| <p>Comments from SDRP Review – 10th November 2021</p> | | |

Figure 2 3pm Mid-Winter Shadow Diagram Extract (Source: Fulton Trotter)

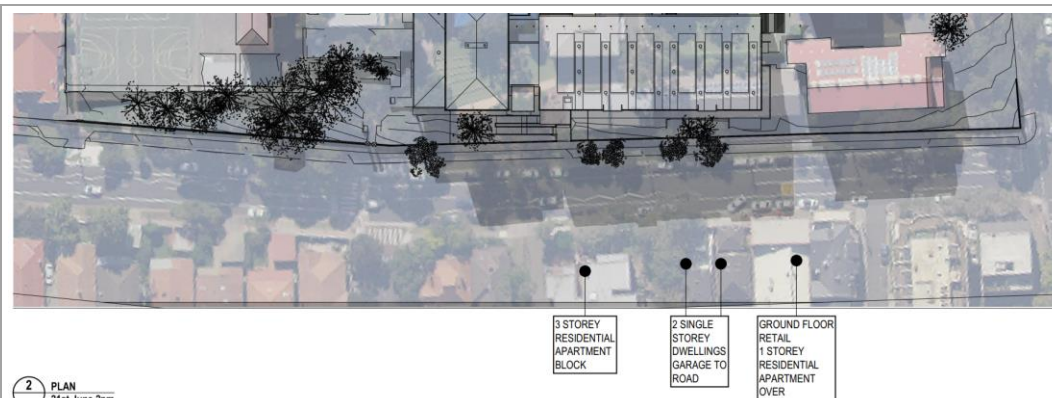
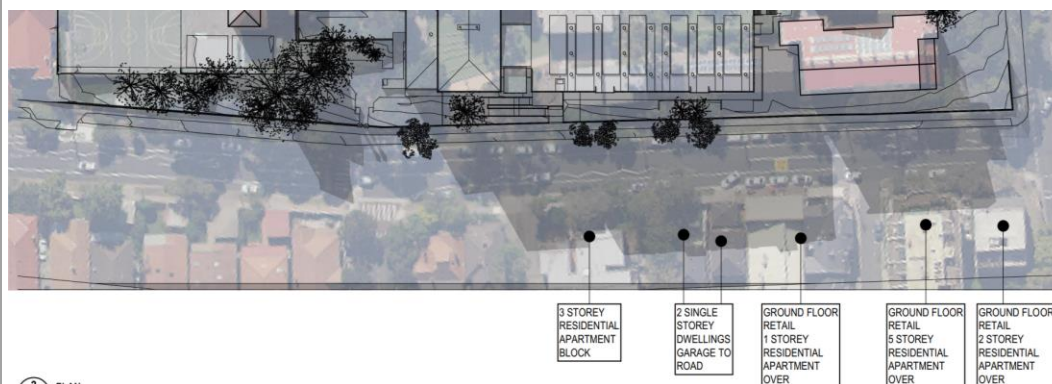
| Item No. | Comment | Response |
|----------|---|--|
| 8 | <p>Shadowing</p> <p>5. Sections 7.3.2 and 7.1.2 of the EIS state that shadows generated by the proposal would not impact surrounding development and that shadows would fall onto Bay Road and the footpath at 3pm in mid-winter. The shadow diagrams lodged with the EIS show that at 3pm shadows are cast across Bay Road and onto properties opposite the site on Bay Road. To allow for proper assessment of shadow impacts, hourly shadow diagrams are required between 12pm and 3pm in mid-winter, and elevation shadow diagrams are required to demonstrate from what time and where shadows will fall on north facing elevations of development opposite the site on Bay Road.</p> | Updated Shadow diagrams have been provided on Architectural Drawings SD-1108 and SD-1108a providing shadow diagrams at hourly intervals as requested. These diagrams indicate that the shadows from this development only begin impacting on the neighbouring properties in mid-winter from 2pm. |

Figure 2: Amended Bay Road entry (Source: Fulton Trotter)

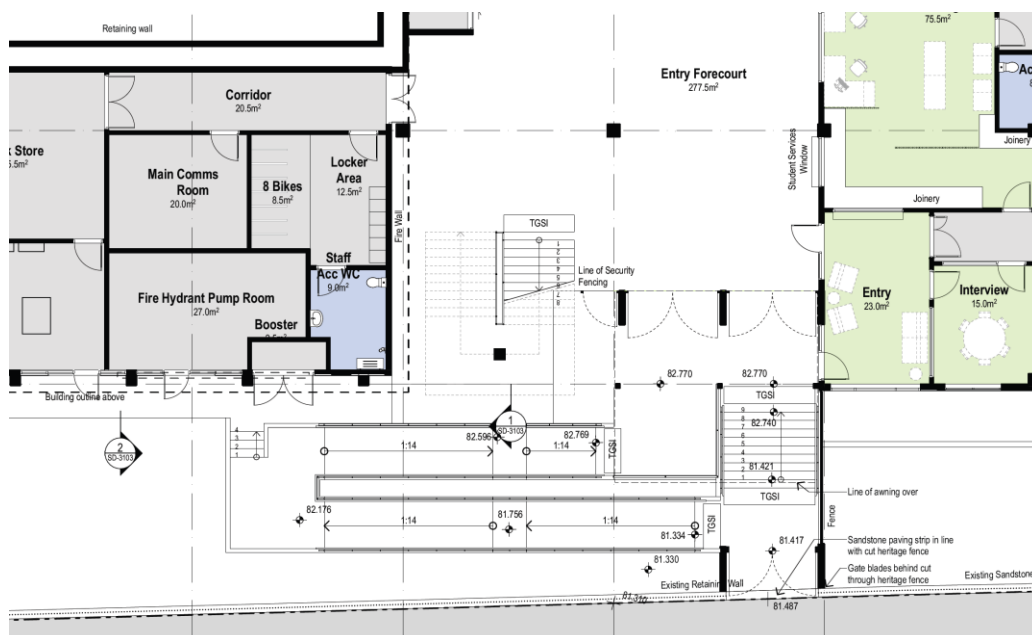
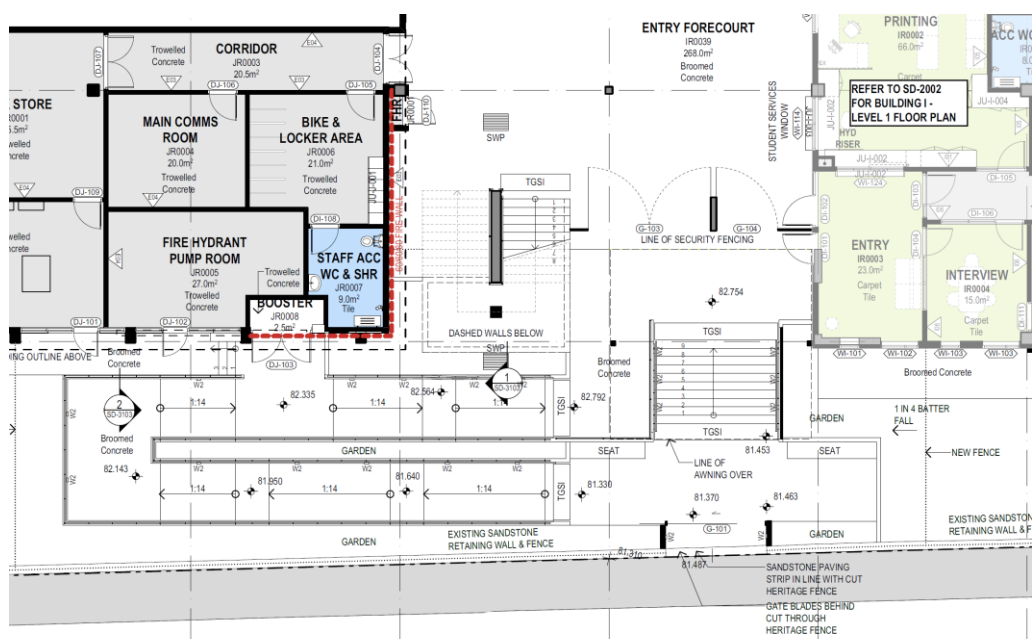
| Item No. | Comment | Response |
|-------------------------------|---|--|
| 1 | <p>Built Form and Urban Design</p> <p>Concern is held that:</p> <p>a) the proposed design of the new entry on Bay Road would not provide an open and inviting entry off Bay Road and its ground area and stairs leading into the school would be constrained potentially not accommodating the number of students likely to use the entry. Further, the proposed dimensions of the access ramp appear to be minimal and could result in access issues for pedestrians and strollers.</p> | <p>In light of the layout and configuration of the entry ramp and stairs and been revised in the following ways –</p> <ol style="list-style-type: none"> 1. Configuration of the entry stair and ramp have been modified to allow the stair to sit centrally under the awning roof. 2. The entry gate has been reconfigured to be a sliding gate rather than swing gates. This limits the space required for the entry gate and allowing for a more generous footpath / gathering space at the bottom of the entry stairs behind the gate. <ul style="list-style-type: none"> • Please note that the width of the gate was reviewed as part of this process. Having discussed the widths with School Infrastructure NSW it was felt that the 3500mm width of the opening in the fence was sufficient for the pedestrian movement needs of the school. Therefore, it is proposed that the gate is not widened in order to limit the impact on the heritage listed fence to Bay Road. • However, the change in the operation of the gate to a sliding gate will allow for the full width of the opening in the fence to be kept clear when the gate is open. • We also note that we did explore the option of creating multiple gate entry points off Bay Road, however, this was not supported by the Heritage consultant due to the impact on the heritage listed fence. 3. We have reviewed the planning of the stairs and ramps in order to widen all circulation paths – <ul style="list-style-type: none"> • The stair has been widened from 3500mm to 4500mm • The ramps have been widened from 1750mm clear to 2100mm clear 4. The configuration of the ramps, stair and landscaping have been adjusted to create an increased forecourt area at street level at the bottom of the stair. This creates spaces for seating and gathering on the Bay Road frontage level at the base of the stairs and ramp. <p>We believe that the outcome of these changes is an entry space that is more generous and welcoming.</p> |

| Item No. | Comment | Response |
|----------|---|--|
| 5 | e) improved entry Bay Road entry design to increase the areas providing standing, movement and access into the school from the entry point. | The entry design has been modified – refer to comments in Item 1 above. Revised Architectural Drawings are attached to this submission. |

Figure 12: Extract of the amended elevation entry signage to Building J (Source: Fulton Trotter)

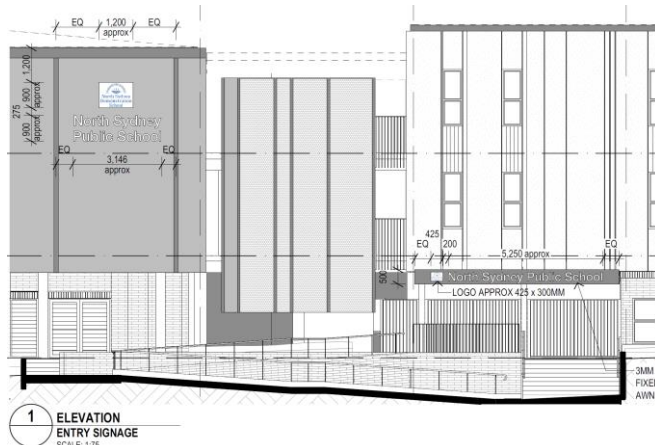
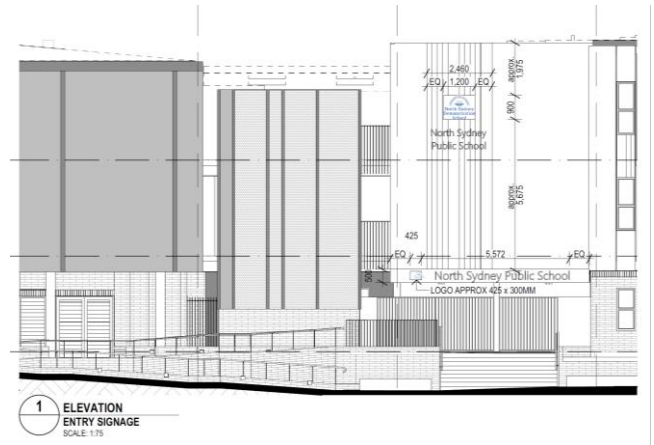
| 23 | <p>Entry Signage</p> <p>The size of the signage panel over the entry is large and out of proportion with the remainder of the building. This should be reviewed.</p> | <p>We have reviewed the layout of the signage in this area – in conjunction with the review of the materiality of the façade in this area. The ‘panel’ that the signage was mounted on has been removed. The signage is now mounted directly onto the CFC panelling in this area and the jointing of the CFC panelling is used to create a framing for the signage.</p> |

Figure 14: Extract of amended east elevation of Building I (Source: Fulton Trotter)

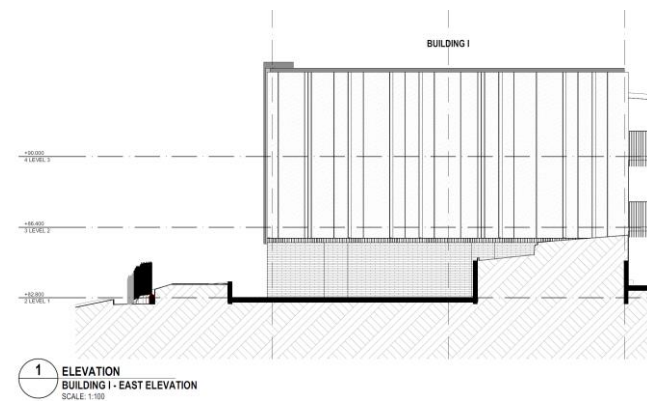
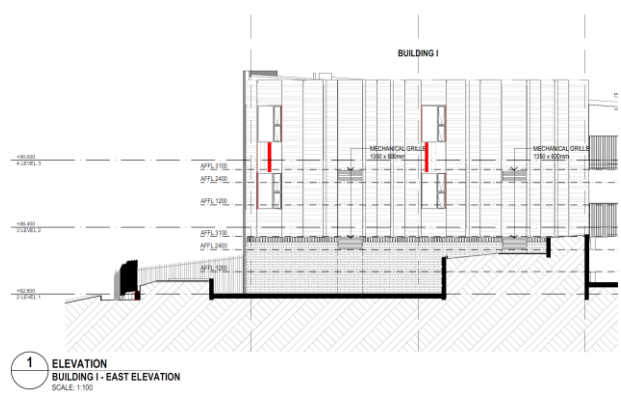
| Item No. | Comment | Response |
|----------|---|---|
| 3 | c) the eastern elevation of Building I proposes full height panels without windows, presenting massing and scale impacts when viewed from Bay Road. | The Eastern elevation of the building has been reviewed in order to ensure it is more consistent with the remainder of the building form. Windows have been created in the façade (within the joinery of the Home Bases in that portion of the building). Further to this, the additional detailing and texture provided by the modification to the façade cladding (as discussed above) softens the impact of this façade and makes it more cohesive with the remainder of the building. |

| 12 | <p>Façade and roof form (Continued)</p> <ul style="list-style-type: none"> The east elevation of the main building is not supported. This façade has full height panels without windows, the architectural expression at this end of the building (as it presents to Bay Street) is not supported as an appropriate fit with the heritage context. This includes concerns about: <ul style="list-style-type: none"> the expression and use of DFMA (refer above), specifically the windows providing an ‘in between’ scale consistent with the aforementioned heritage principle. the lack of fenestration generally to deliver amenity | <p>The Eastern elevation of the building has been reviewed in order to ensure it is more consistent with the remainder of the building form. Windows have been created in the façade (within the joinery of the Home Bases in that portion of the building).</p> <p>Further to this, the additional detailing and texture provided by the modification to the façade cladding (as discussed above) softens the impact of this façade and makes it more cohesive with the remainder of the building.</p> |
